6 November 2020

**Kings Park Metal Recovery and Recycling Facility Expansion (SSD-10396)  
Request for Additional Information**

## ATTACHMENT 1

OWN	CHECK	APP'D	DATE
M	SB	WJ	18/10/19

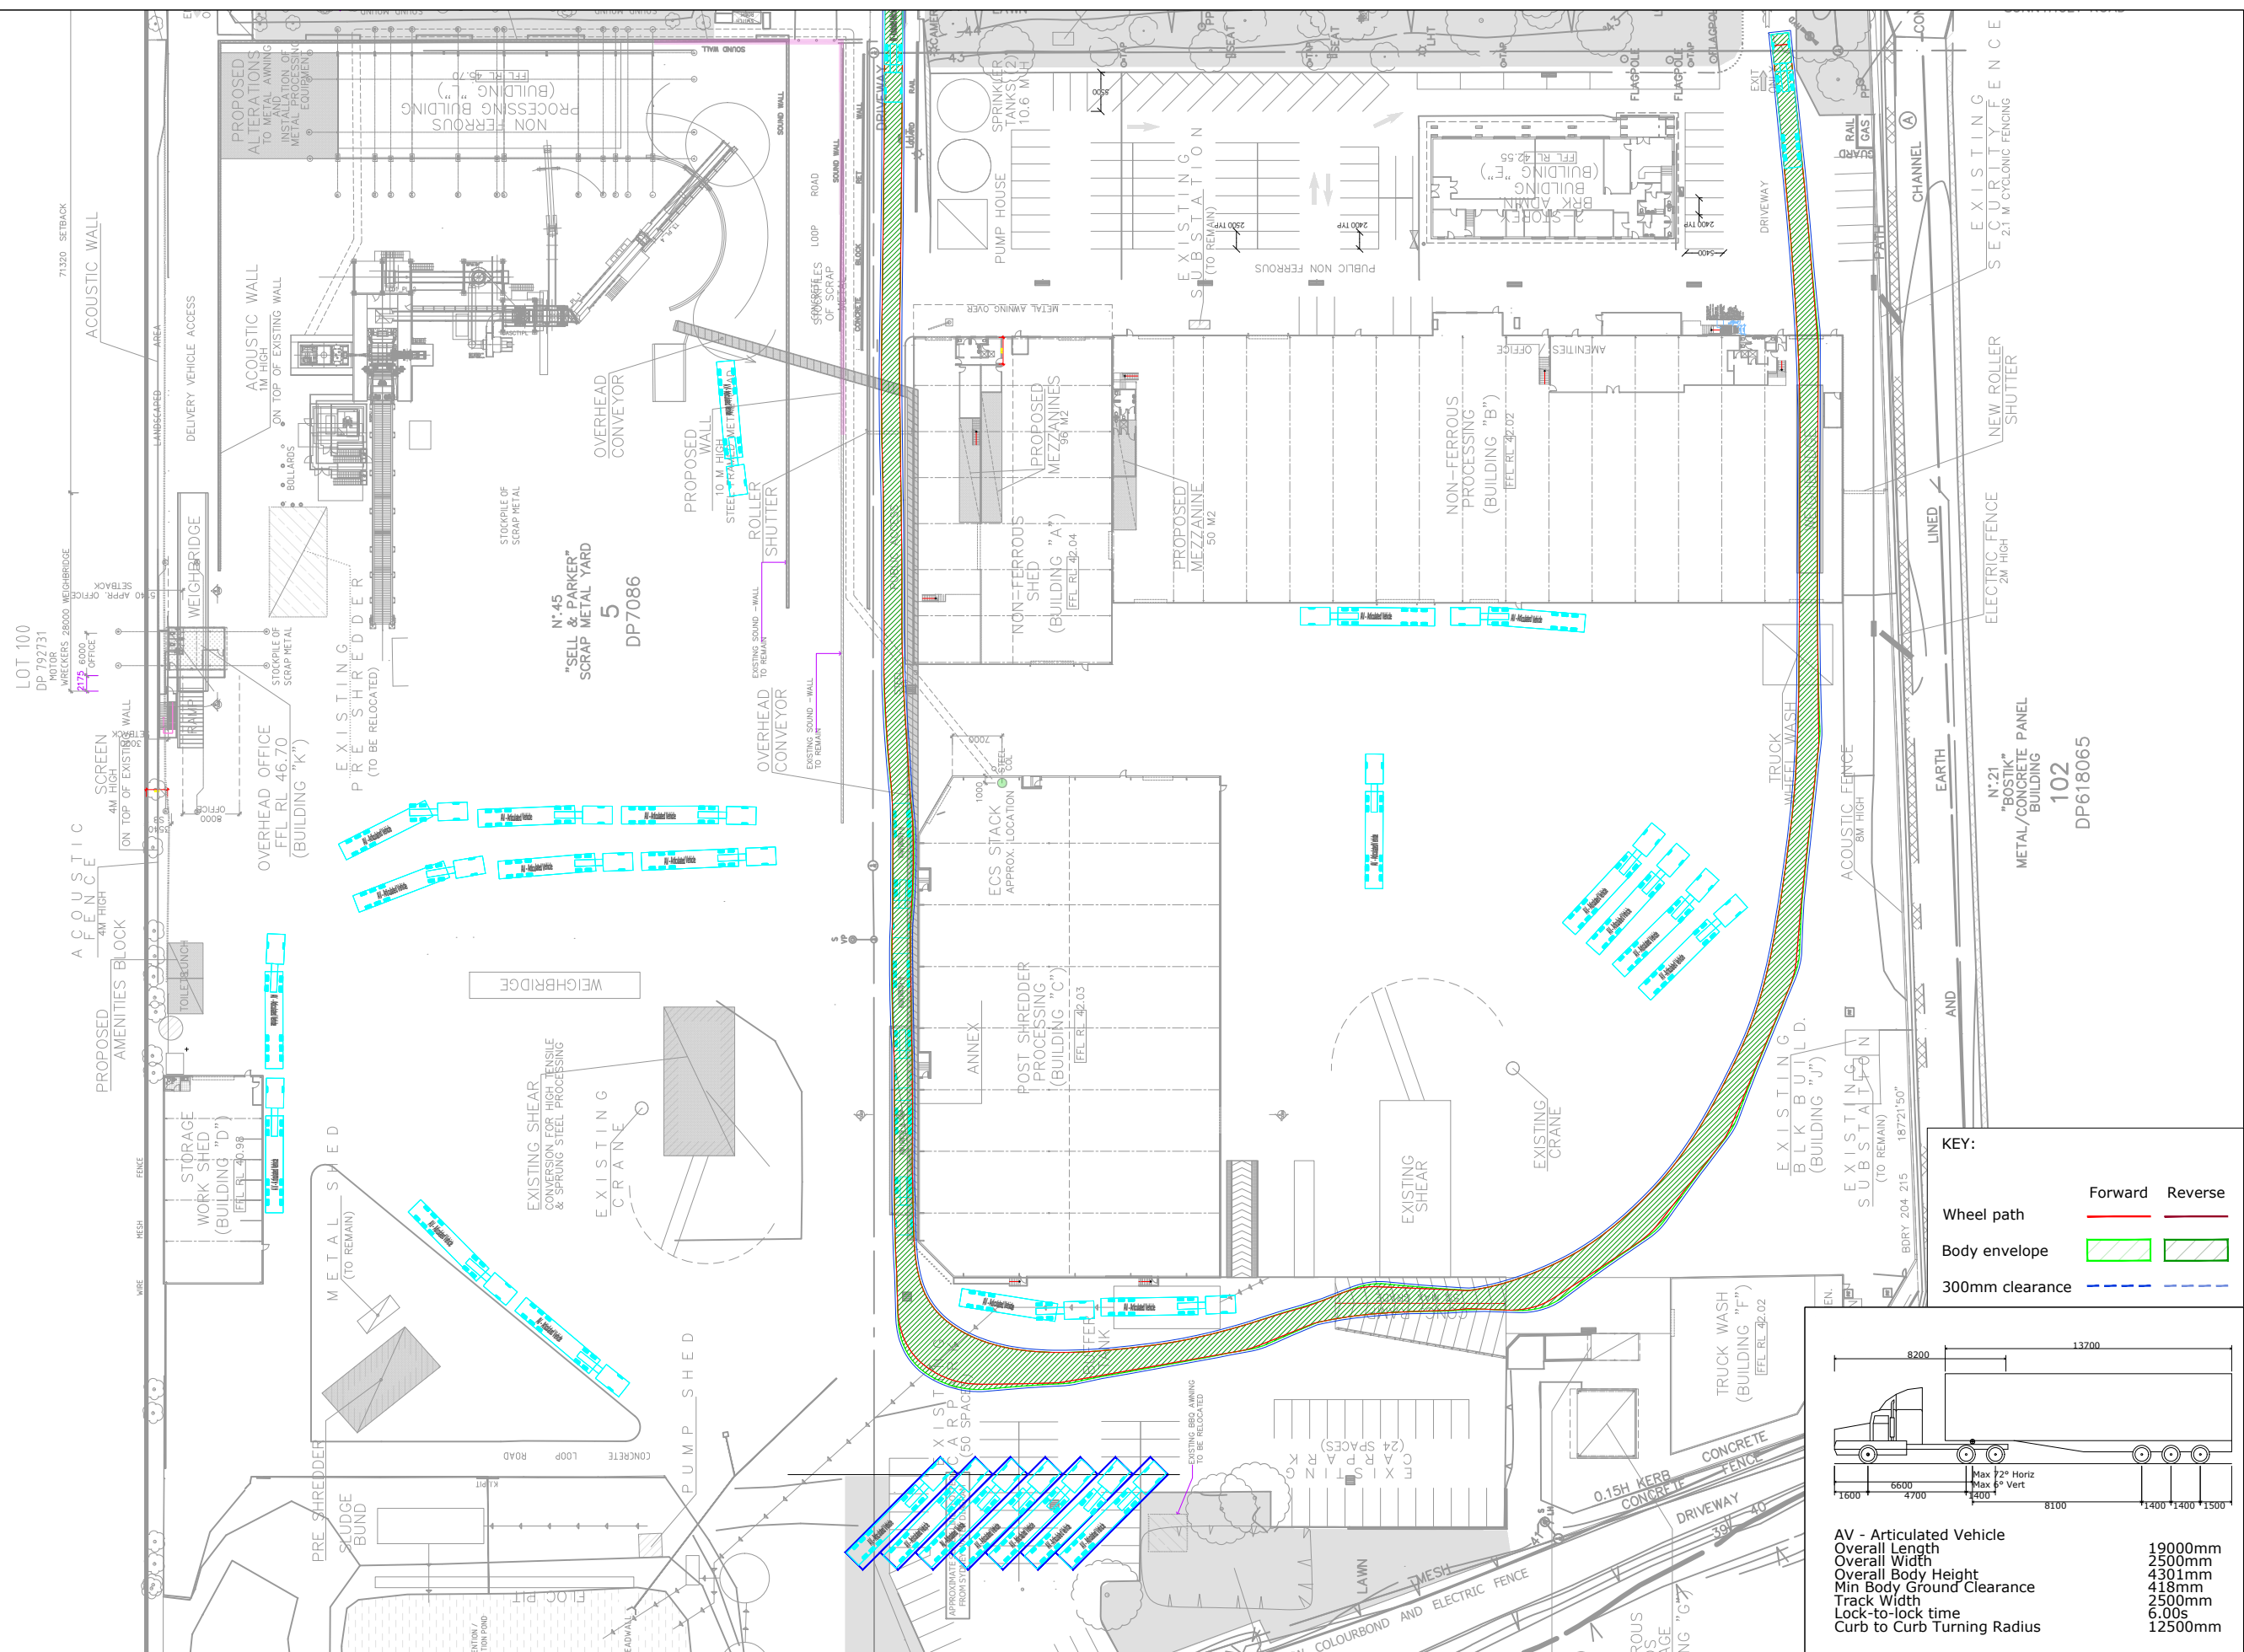
- It is noted the site has three weighbridges: one entry, one exit and one adjacent to one of the shears. Please explain the purpose of the central weighbridge. If its use is associated with the central entry (non-ferrous material), please explain why its use is not shown on the swept path analysis for those vehicles using the central entrance.

- It is noted the assessment identifies peak periods which were used to assess impacts across the scenarios. Please clarify whether these are peak periods for the road network or for the facility.
- It is noted that swept paths have been provided, however, the plans do not include stockpiles. Please update the plans to include stockpiles and ensure the swept path analysis demonstrates that vehicles can safely access the relevant stockpile.
- Table 6.2 in the traffic assessment provides a Stacking Capacity Assessment, however it is unclear whether the number of vehicles accessing the site in an hour represents peak operational periods. If not, please update the table for peak operational periods

Figure 1: Comparison of windrose plots

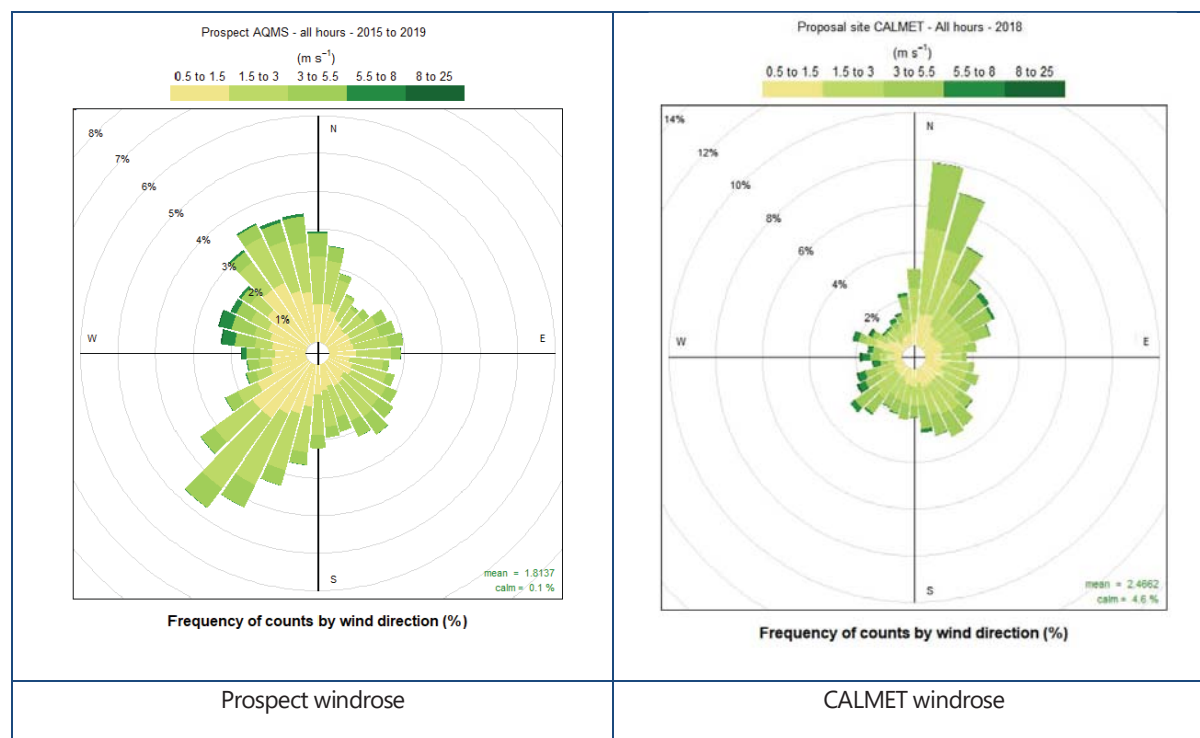
- It is noted that a prevailing wind condition of 3 m/s was modelled as a feature of the area for R1 in the 2014 NVIA (SSD 5041). It is not clear why the prevailing wind condition has not been applied to residential receivers in the Blacktown area in the 2020 NVIA. Further, it is not clear how the meteorological data at the Horsley Park Equestrian Centre was applied to represent local conditions in the Blacktown locality. Please, at a minimum, provide wind rose plots and an accompanying analysis/discussion.
